Re: Weigall Sports Complex, Sydney Grammar School (SSD-10421)

Comments on visual impacts issues in Draft Conditions V2.

1 Purpose of this response

Location Description:
Living room of unit 9,
8 Vialoux Avenue

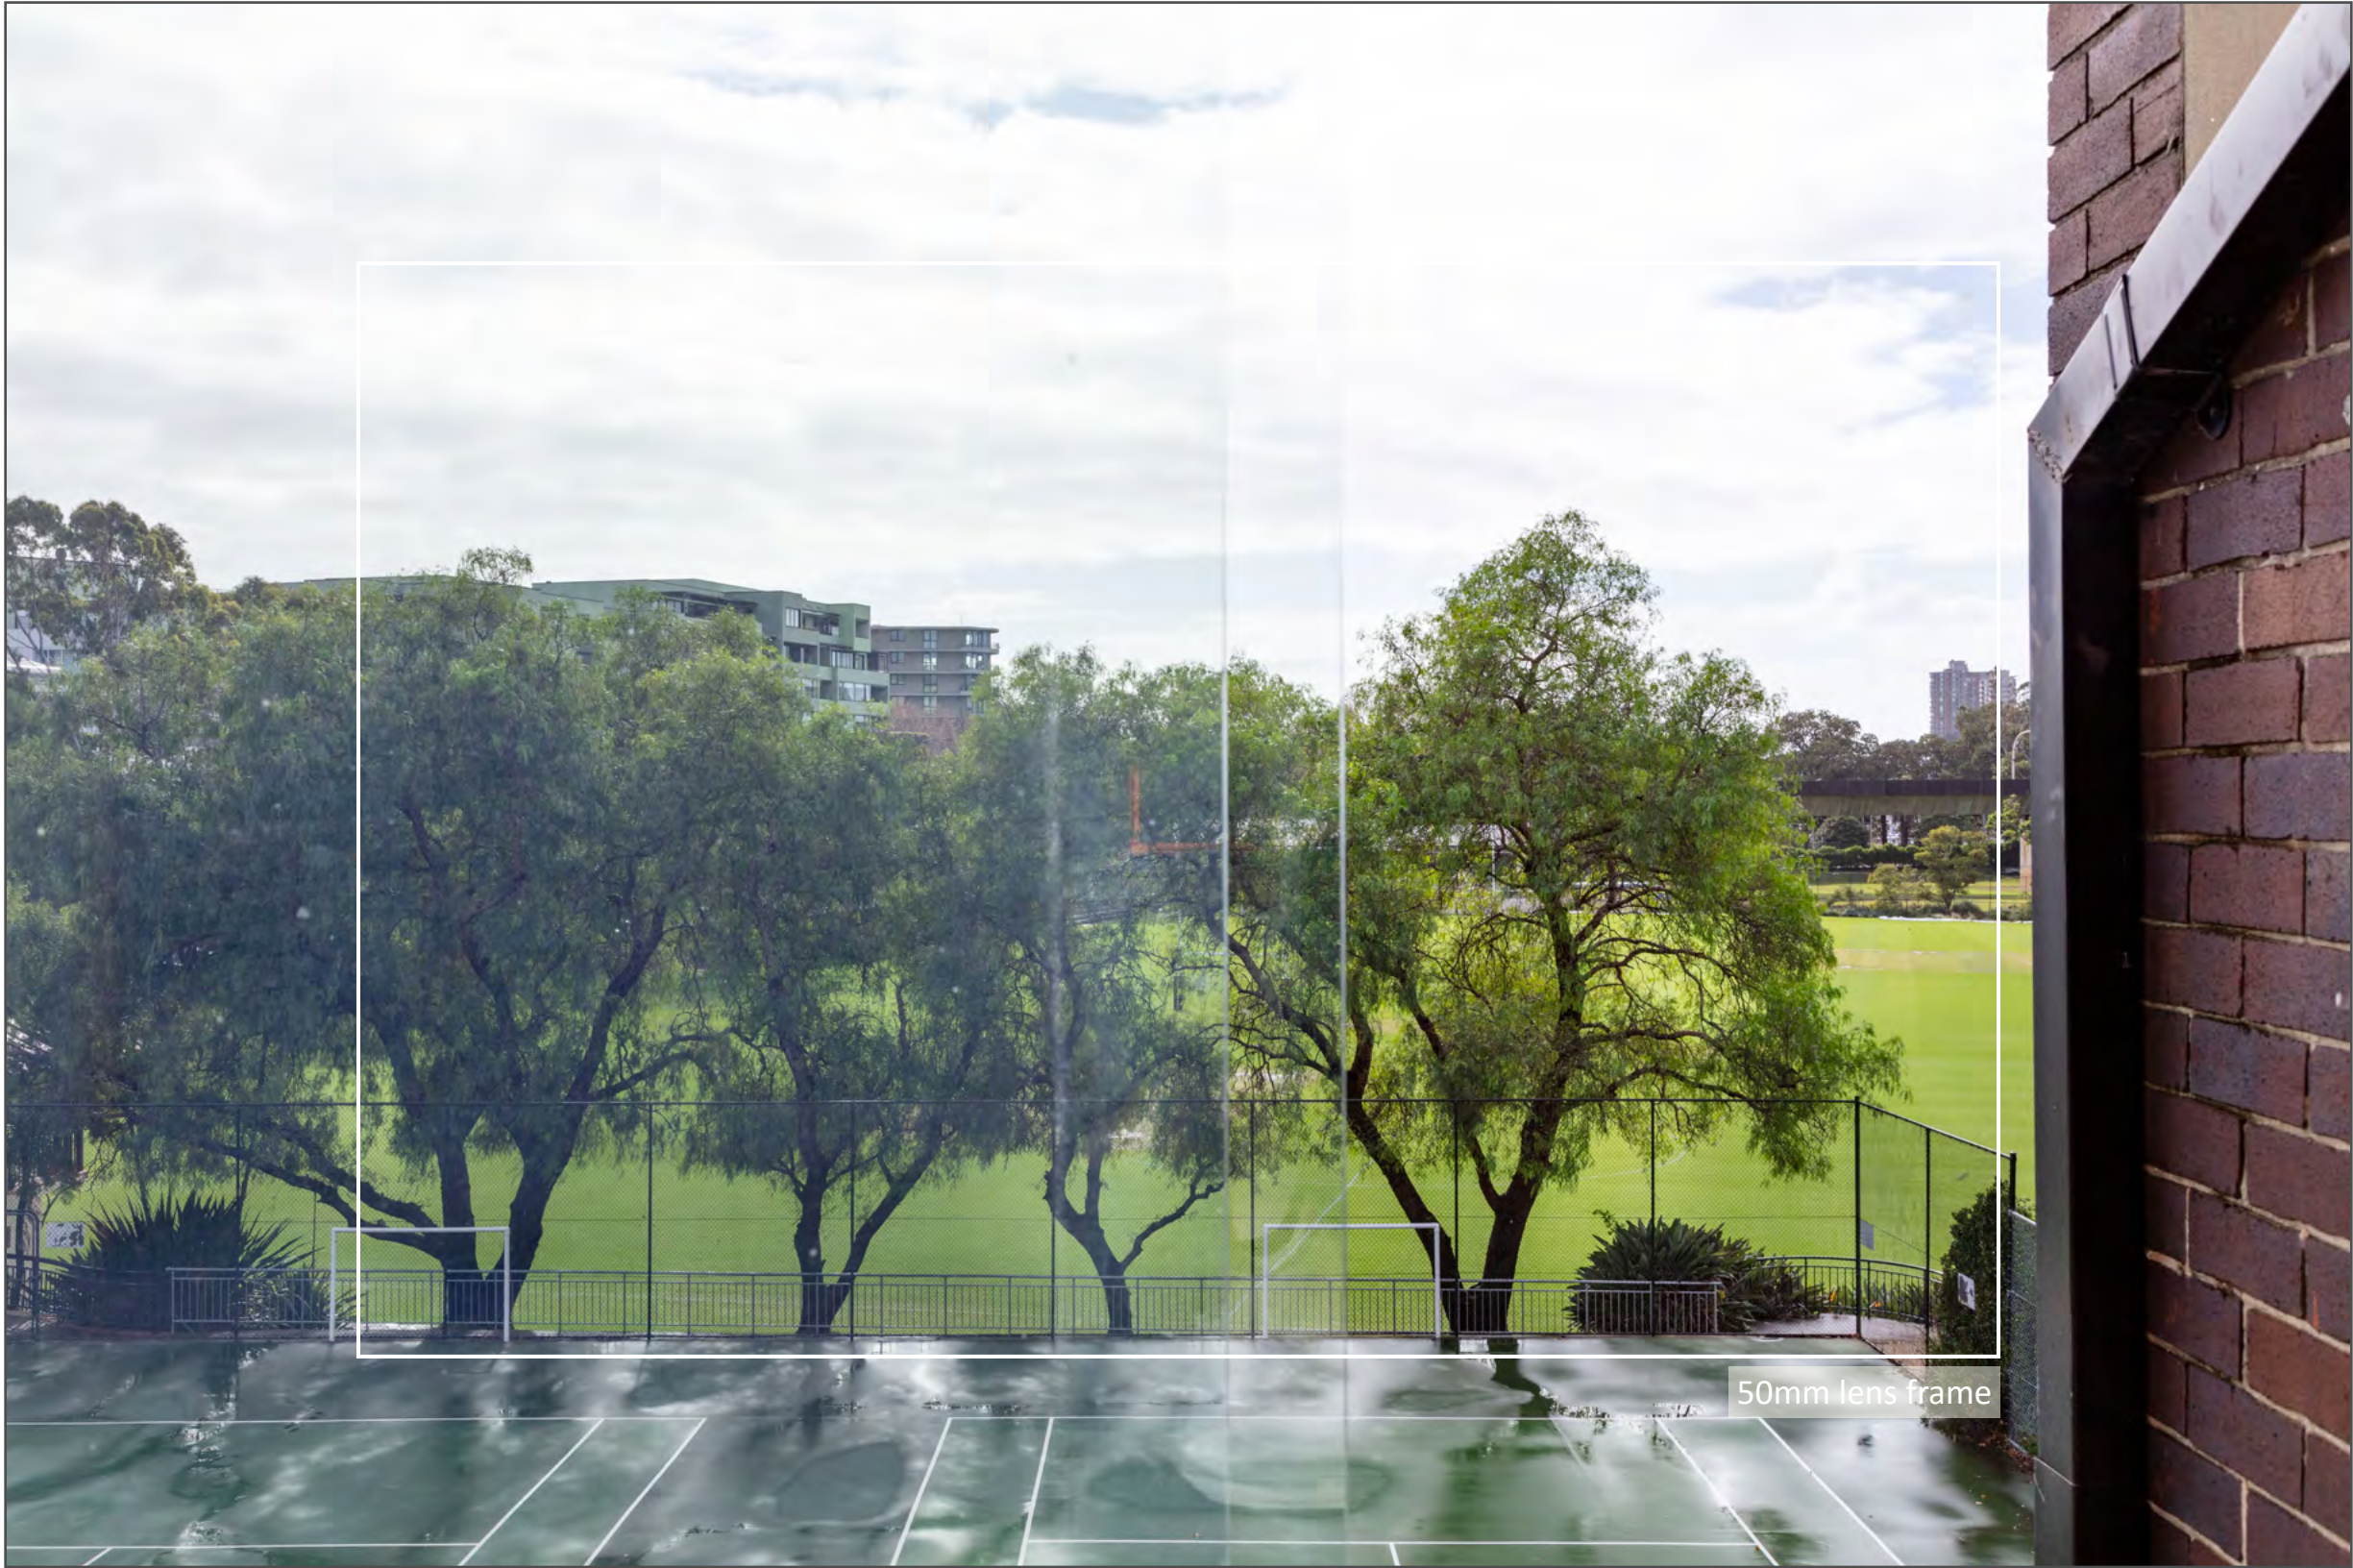
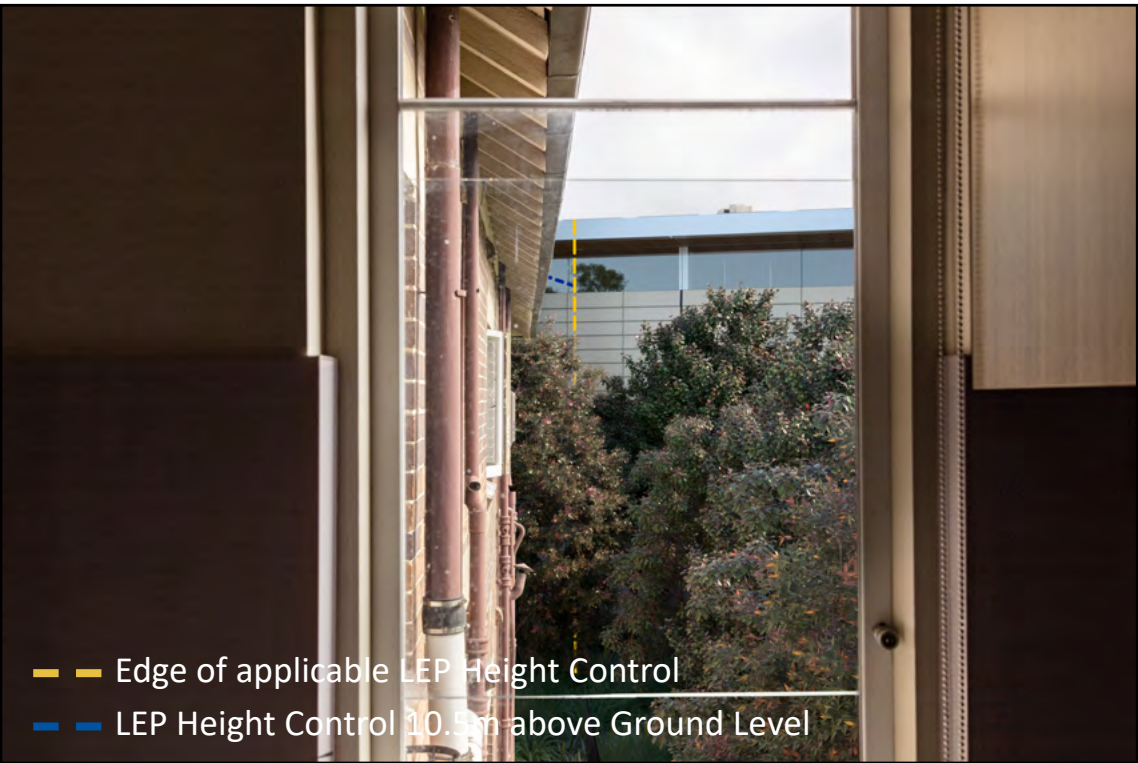
totally constructed, dominated in the foreground by tennis courts and in the middle distance by level grass, all private, school land. The conclusion below in this regard by Urbis, appears to be justified:

Features of the northerly views whilst providing a pleasant outlook are not considered iconic, scenic and highly valued in Tenacity terms.

As noted above, it is not logical or valid for the extent of visual impact to be assessed later in Step 3 as devastating, which is the highest level on the subjective scale of impacts, when the attributes of the views that were identified in Step 1 are below the highly valued level.

I accept of course that the views that are currently available would be largely lost and replaced with built form and landscape, the closest part of which would be Building 1. It is a very substantial change to the character of the view, however the impact rating in Step 3 is a rating of the importance of the effect (this what impact is), as distinct from the extent of the change (how much of a visual effect there is). The impact rating depends on the importance of the change in the quality and the quantum of the view. This is explained in the general methodology of the VIA by Urbis.

Views are obtained from 8 Vialoux Avenue across the side boundary, a view orientation more difficult to protect as noted in *Tenacity*, giving less weight to the importance of the impacts that will be determined in Step 3. Although it might be said to be a minor down-weight factor, it also suggests that a maximal view impact in Step 3, of devastating, would not be a valid outcome.

As noted above, *Tenacity* does not clearly distinguish between the quantum of visual effects, (how much change or view blocking) and the extent of impact. This can lead to overestimation of the extent of the impact, if the quantum of visual effects (how much change) and the extent of the impact (the importance of the impact) are equated. In the case of the Urbis assessment in relation to 8 Vialoux Avenue, in my opinion, the quantitative extent of the view to be lost has been given undue weight and has resulted in an exaggerated and unjustified extent of impact assessment, as devastating. In my opinion, the impact on the views assessed would be better characterised as moderate to severe.

In my opinion, in relation to the refined Condition B1 wording proposed by SGS, the extent of visual impacts of Building 1 on 8 Vialoux Avenue the reasoning for which is set out above would be moderate to severe.
